**SUBMISSION FOR APPLICATION No. SSD5752**

**Please find below letter that OBJECTS to the current Development Application SSD5752.**

We are owners in the Goldsbrough, a historical residential building of approximately 500 apartments, which is located directly behind the proposed ICC Convention centre.

ICC CONVENTION

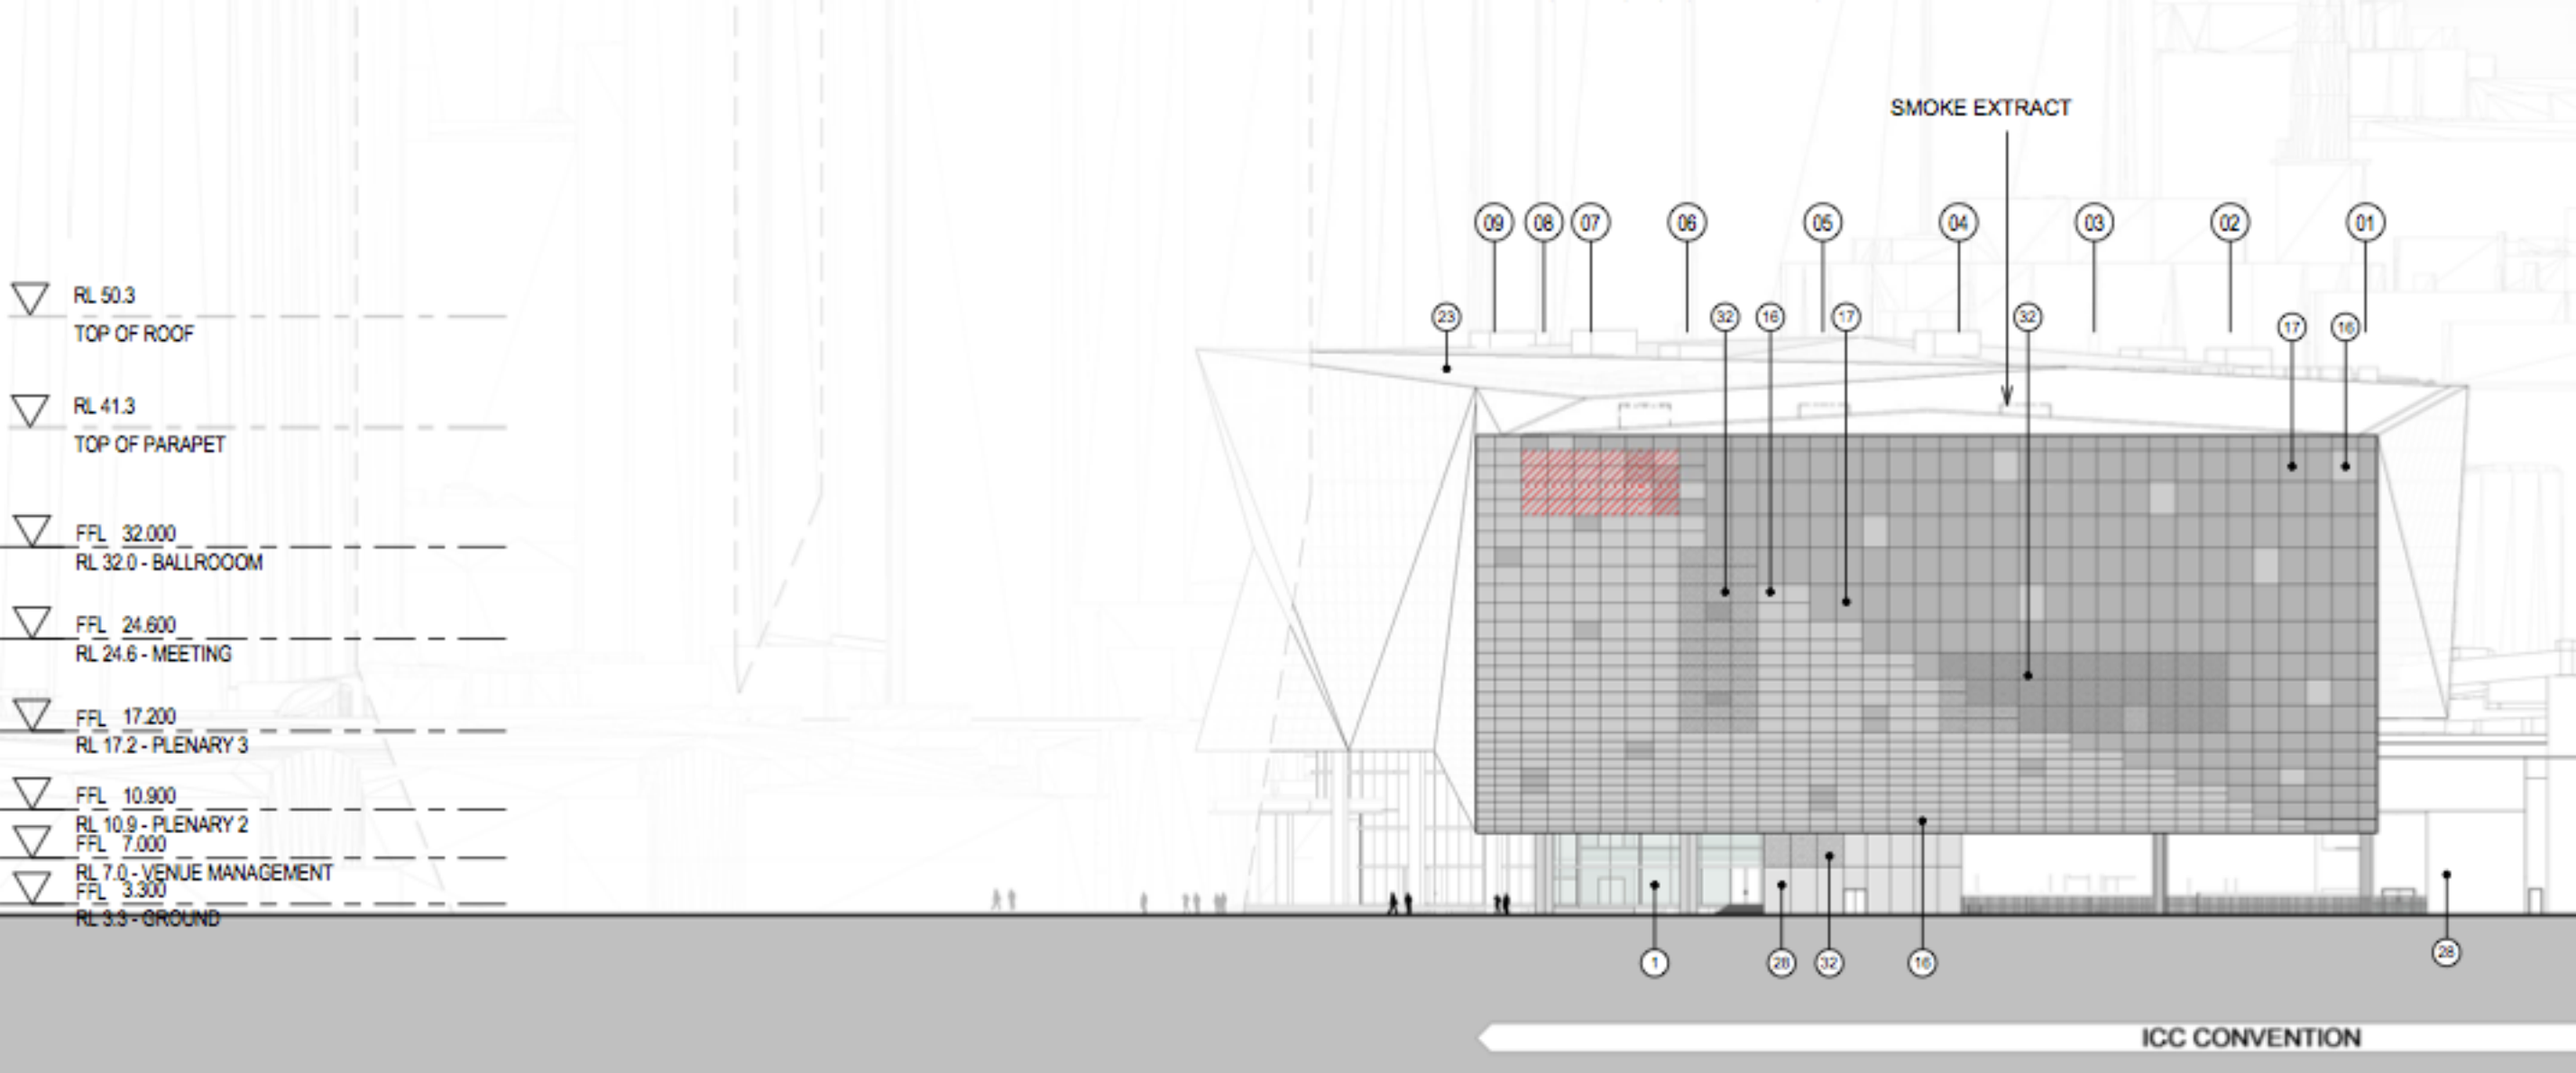
We object to the height of the proposed new ICC which is planned to reach nearly to the top of the Goldsbrough's current height. In DA plans the proposed height RL 50.3 will block the entire view to Darling Harbour and the city from the Goldsbrough's eastern facing apartments. As a heritage building the current views for the eastern facing apartments are a significant part of the iconic building attraction. Removal of these views will reduce property prices and increases the risk the current building becomes less attractive for property owners and will turn into a vacant ghetto which will be to the detriment of the area.

In place of the current city skyline and Darling Harbour view there will be a flat blank metallic wall in its place, which is the rear of the proposed ICC building. While the front of the ICC building is designed with glass and is broken up in angles, but the Goldsbrough will be facing an ugly flat back wall made of aluminum and mainly Grey.

See the diagram of the back of the ICC below, which will be approximately the same height as the Goldsbrough.

As the height of the proposed ICC is nearly the current height of the Goldsbrough, any outlook from the Goldsbrough to Darling Harbour will be dominated by the Western (rear) face of the ICC. All the publicity shots show the view of the East face yet all the Goldsbrough will see is the ugly utilitarian Western face.

If the view from the Goldsbrough is to be dominated by the ICC then at least some regard should be paid to the fact and the Western face of the ICC modified to be more aesthetically appealing. The western face could be architecturally articulated and made of materials that don't look like a metal barricade.

See Diagram below for view of the Western face of the ICC facing the Goldsbrough. Note the scale of this wall in relation to the people in the picture.
